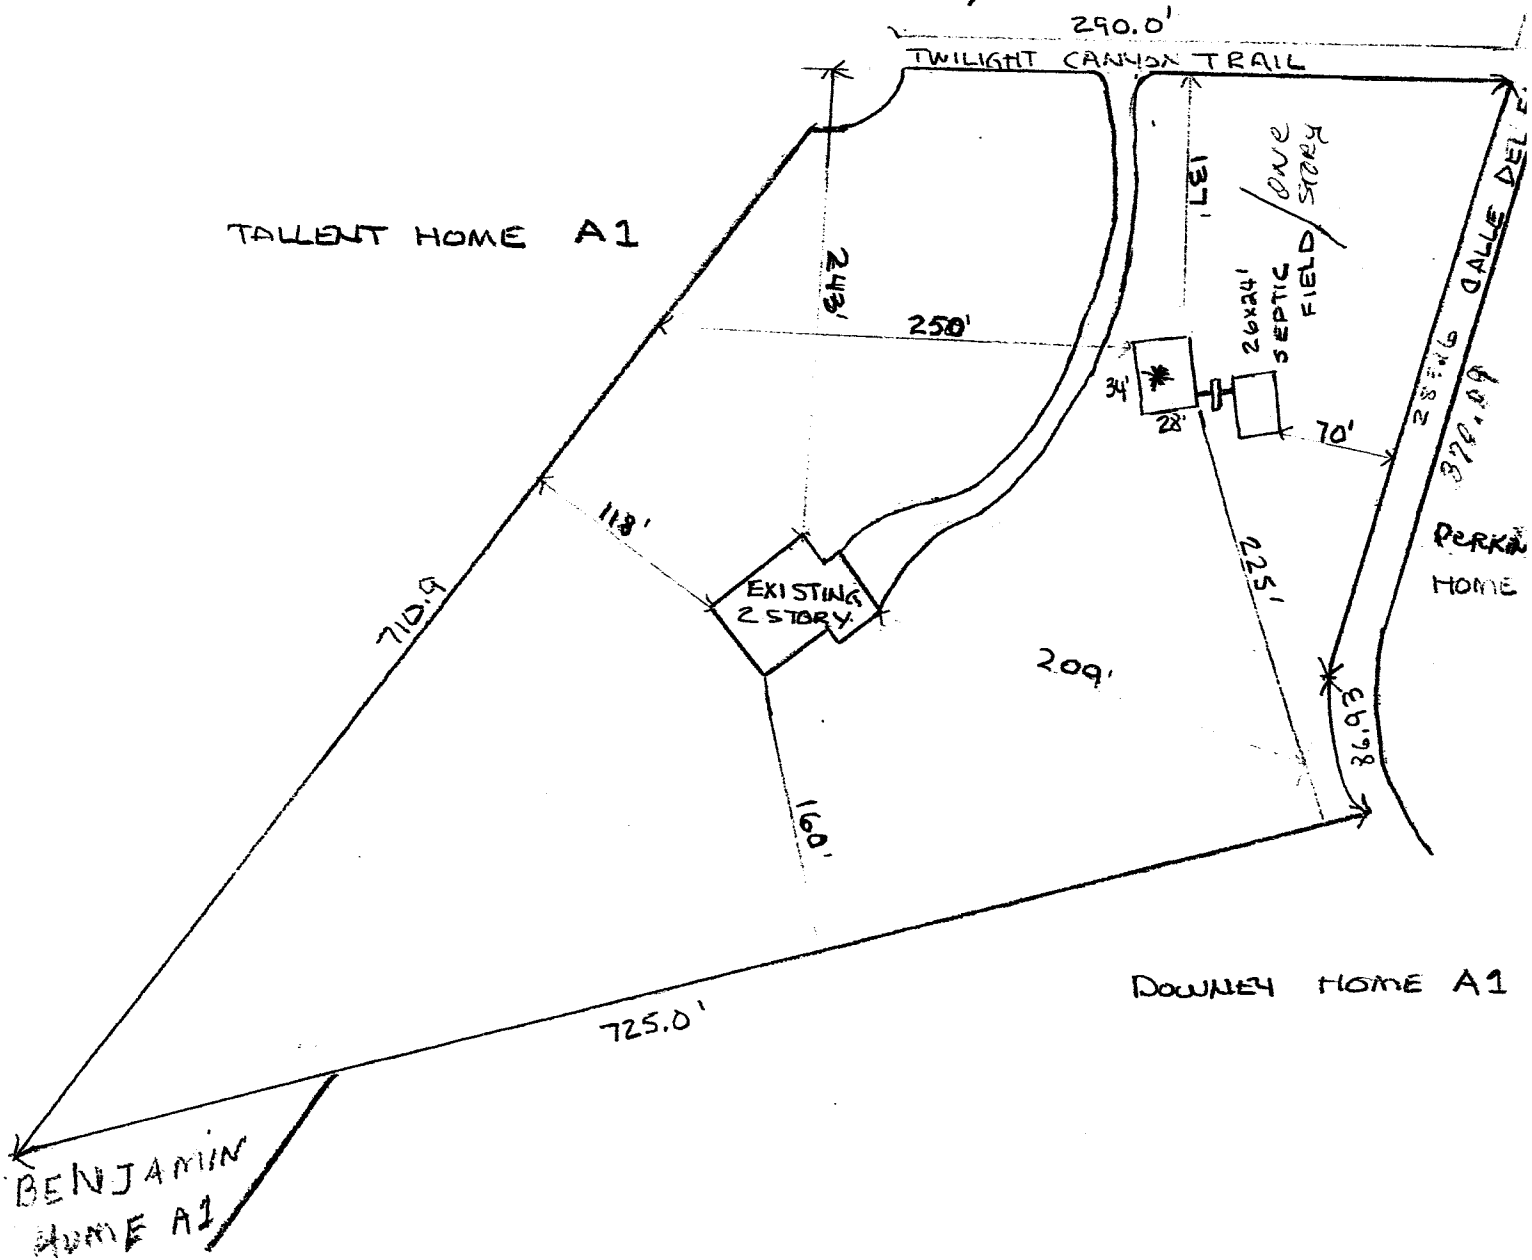
Change this to say guest house or guest house structure.
